STATE OF WASHINGTON  
DEPARTMENT OF ECOLOGY

January 19, 2018

Re: SP-17-00003

Thank you for the opportunity to comment on the short subdivision of approximately 123.87 acres into 3 lots, proposed by Cruse and Associates for Basil Sinclair. We have reviewed the application and have the following comments.

NANEUM ROAD SHORT PLAT  
 PART OF SECTION 33, T. 18 N., R. 19 E., W.M.  
 KITTITAS COUNTY, WASHINGTON

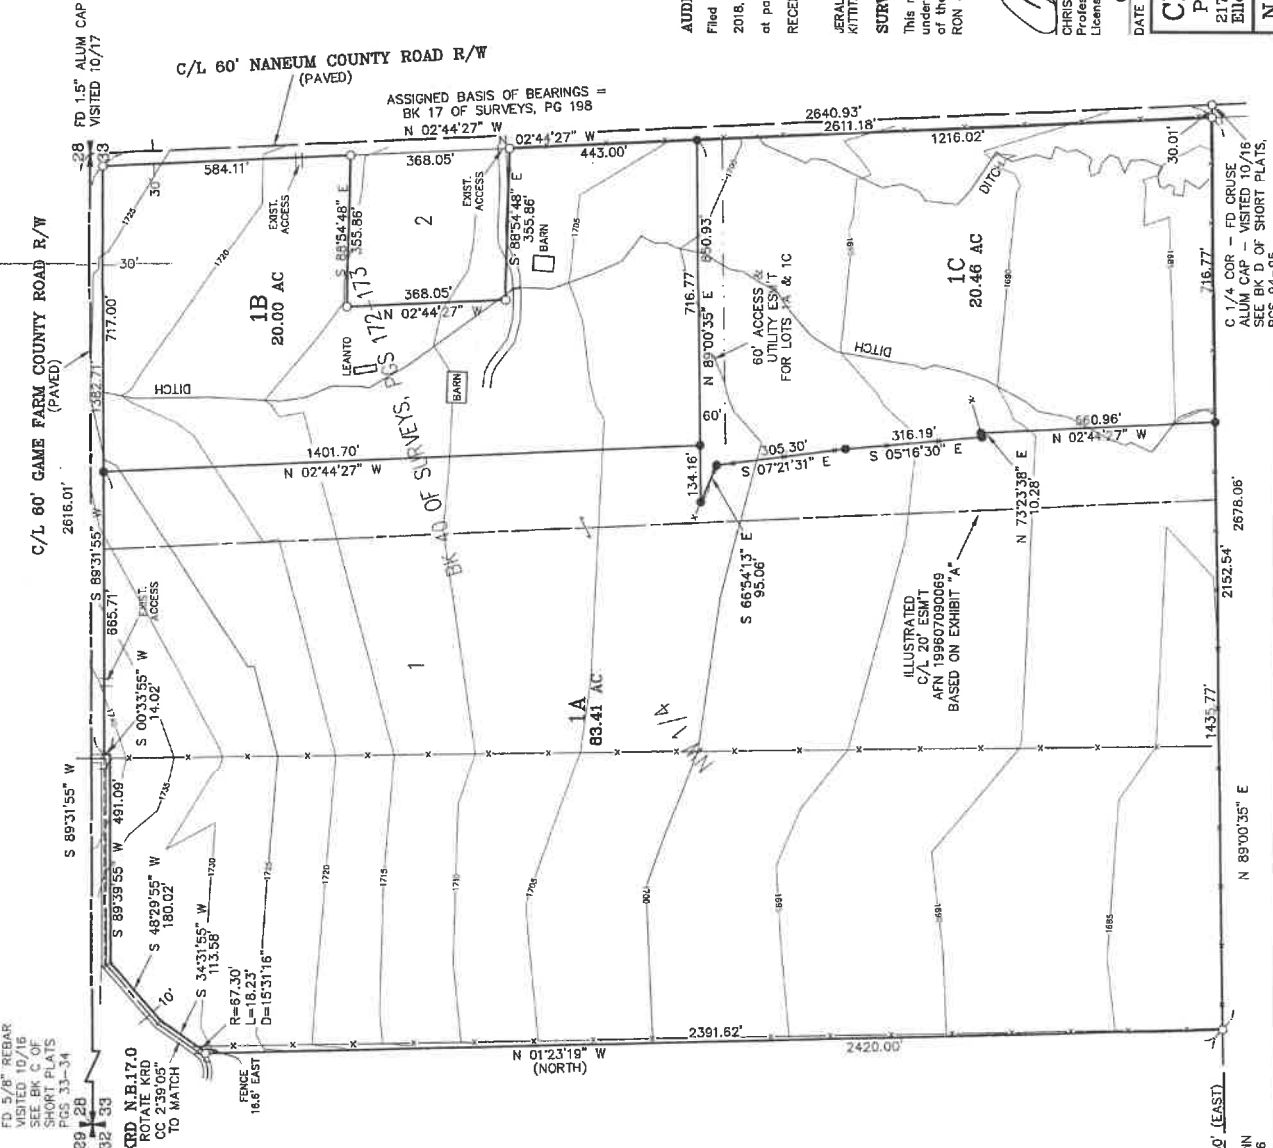
The actual subdividing of the parcel will not result in impacts; however, building on the parcel could produce streams, stream buffer, wetland and wetland buffer impacts. Three unnamed tributary streams, Naneum Creek, and potential wetland habitat exists on and/or adjacent to the parcel.

Naneum Creek is regulated under Kittitas County's Shoreline Master Program and has a rural conservancy environmental designation, which requires a 100' vegetation buffer extending landward of the ordinary high water mark (OHWM). Buffers along the remaining three streams will need to be determined per the stream type, found within Kittitas County Code 17A.07.010. Each stream should be properly typed, OHWM established, and buffer widths determined by a qualified professional prior to any construction activities.

Hydrologic signatures and vegetation shifts are most heavily noted in the SE corner between two of the tributary streams. Additional areas of interest occur scattered around the streams. A formal wetland delineation and rating should be conducted by a qualified professional prior to any construction activities to determine wetland locations, wetland category, and buffer requirements.

Identifying the stream, wetland, and buffer habitats and locations prior to platting can help determine the amount of buildable area present. The information should be provided within a report and submitted to the County and the Department of Ecology for review.
